**Application by The North Lincolnshire Green Energy Park Limited for North Lincolnshire Green Energy Park  
The Examining Authority's written questions and requests for information (ExQ1)  
Issued on 23 November 2022**

**Responses are due by Deadline 2, Thursday 15 December 2022**

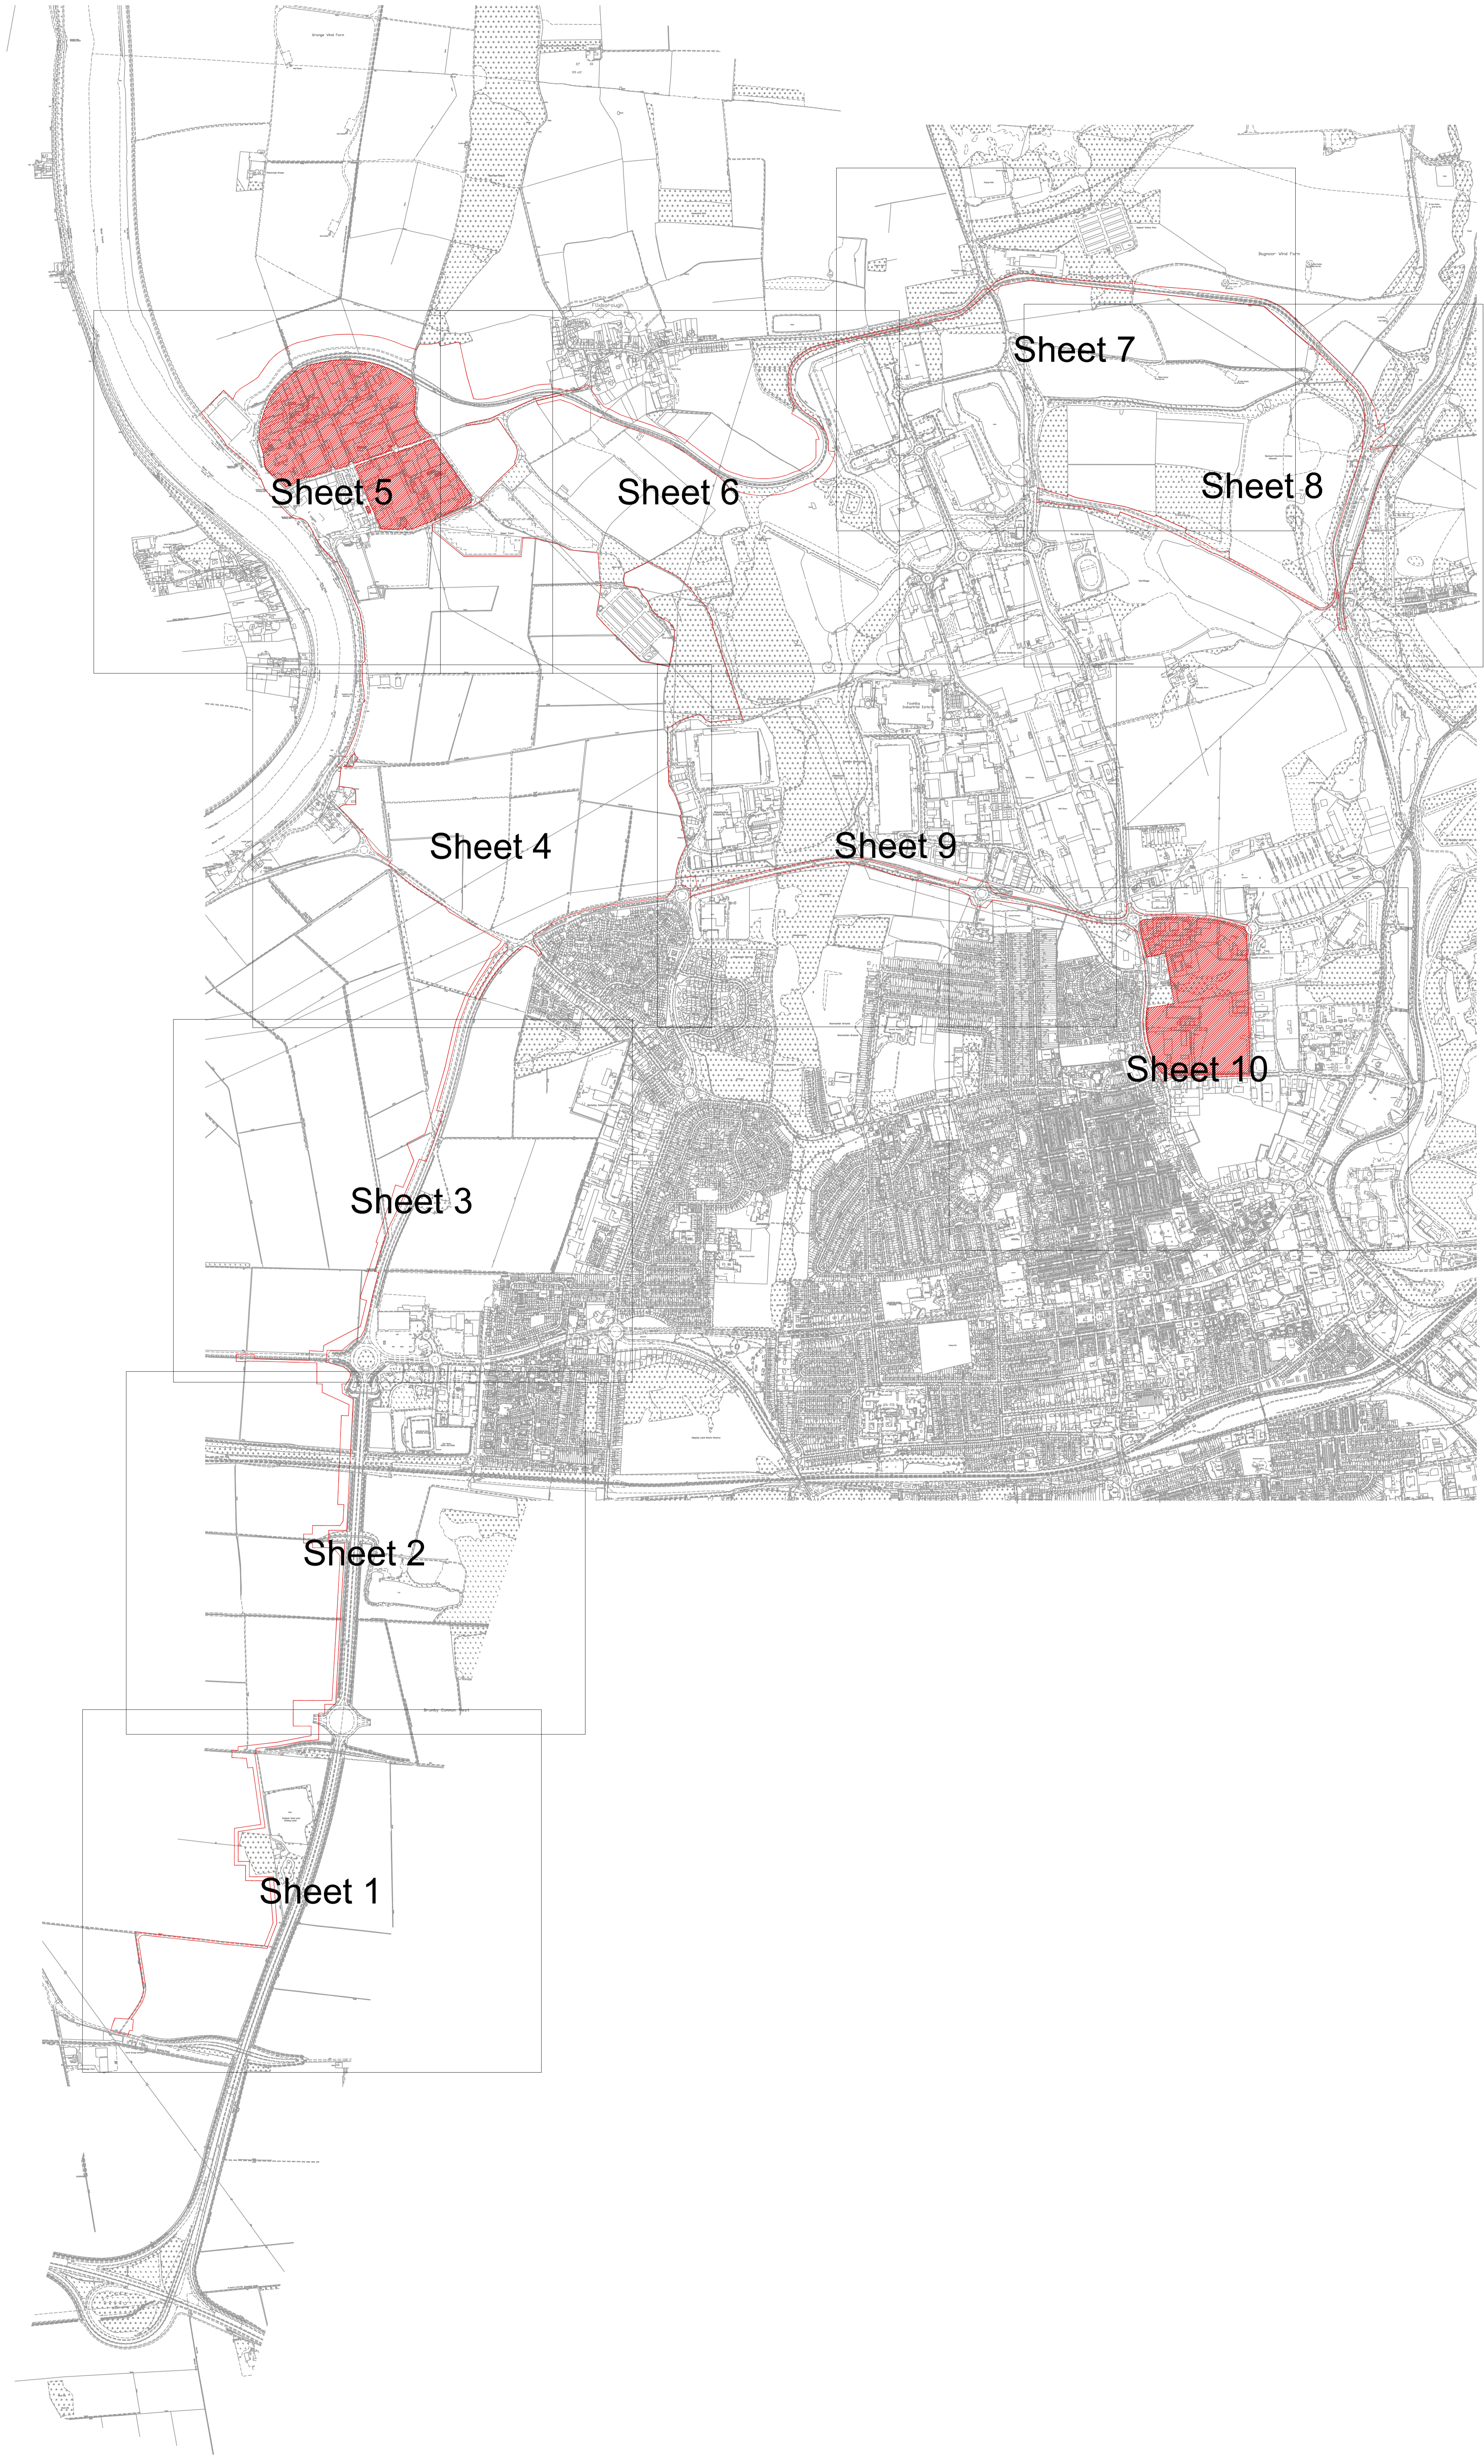
Q1.0.6	The Applicant	<p><b>Plans</b></p> <p>(i) Please clarify with respect to the redline boundary for the DCO where the western most part of the site extends to. Does it include the full extent of the timber protection up to the riverside face of the wharf?</p> <p>(ii) If this is not the case, please explain how appropriate controls can be secured for the whole of the operational wharf area.</p>
Q1.0.7	The Applicant	<p><b>Cross referencing within documents</b></p> <p>(i) When cross referencing within documents please ensure that not only the document is referenced, but the page and paragraph number is also provided, so it is clear where the referenced material can be found. Please ensure this is the case in all future submissions or in response to written questions</p> <p>(ii) [APP-042] Doc 5.8 Consents and Licenses – Table 2.1, item 25 Please advise where Table 4.1 in the Design and Access Statement can be found or provide a corrected reference.</p>
